The Member-Secretary,
Madras Metropolitan
Development Authority,
No.8, Gandhi-Irwin Road,
Egmore, Madras-600 008.

Lr.No. 12/14701/90

Sub: MMDA - Planning Permission - Construction
of Residential

building in Plot No.27 at
S.No.36/9 of Pulliyur village - Approved -
Regarding.

SITE KEY PLAN
(NOT TO SCALE)

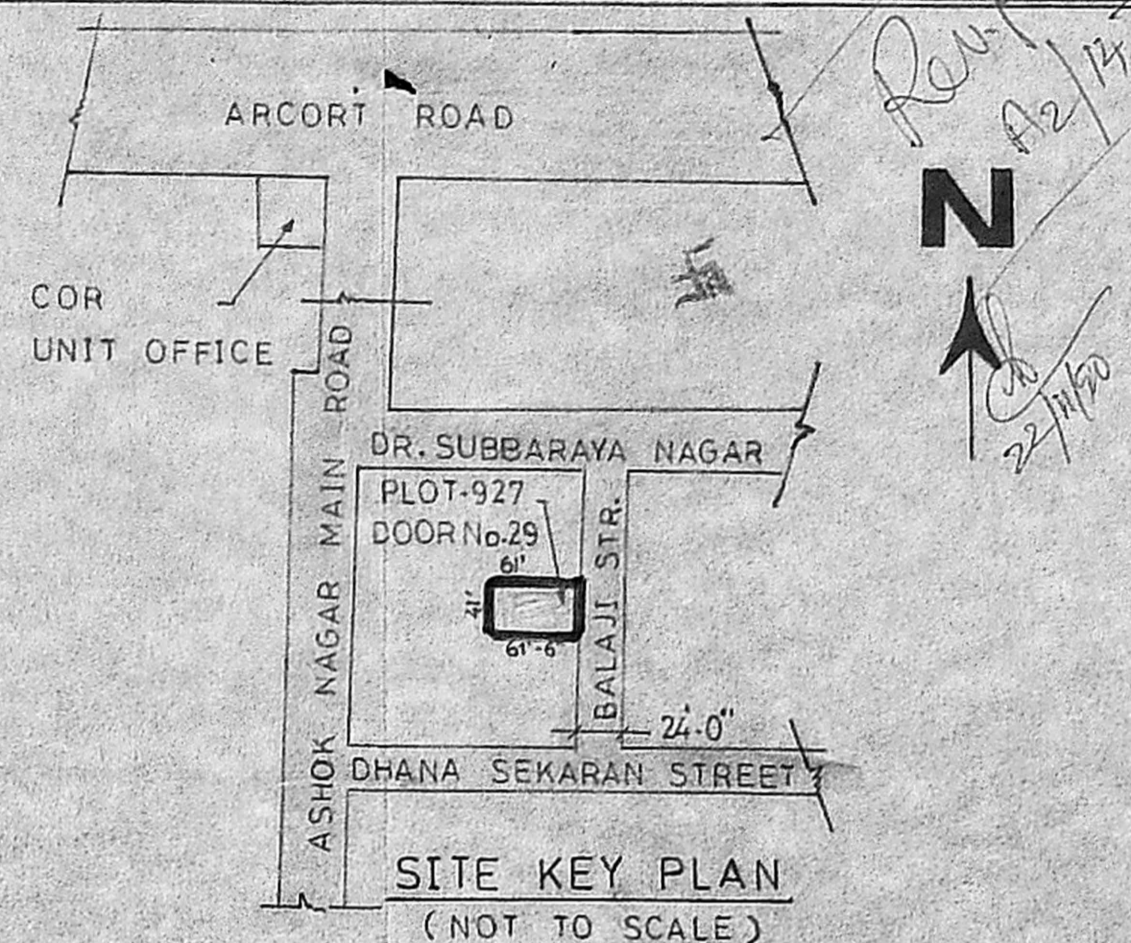
You are also requested to furnish
revised plans (Six Nos) showing Front set back as 18'00" as site
condition.
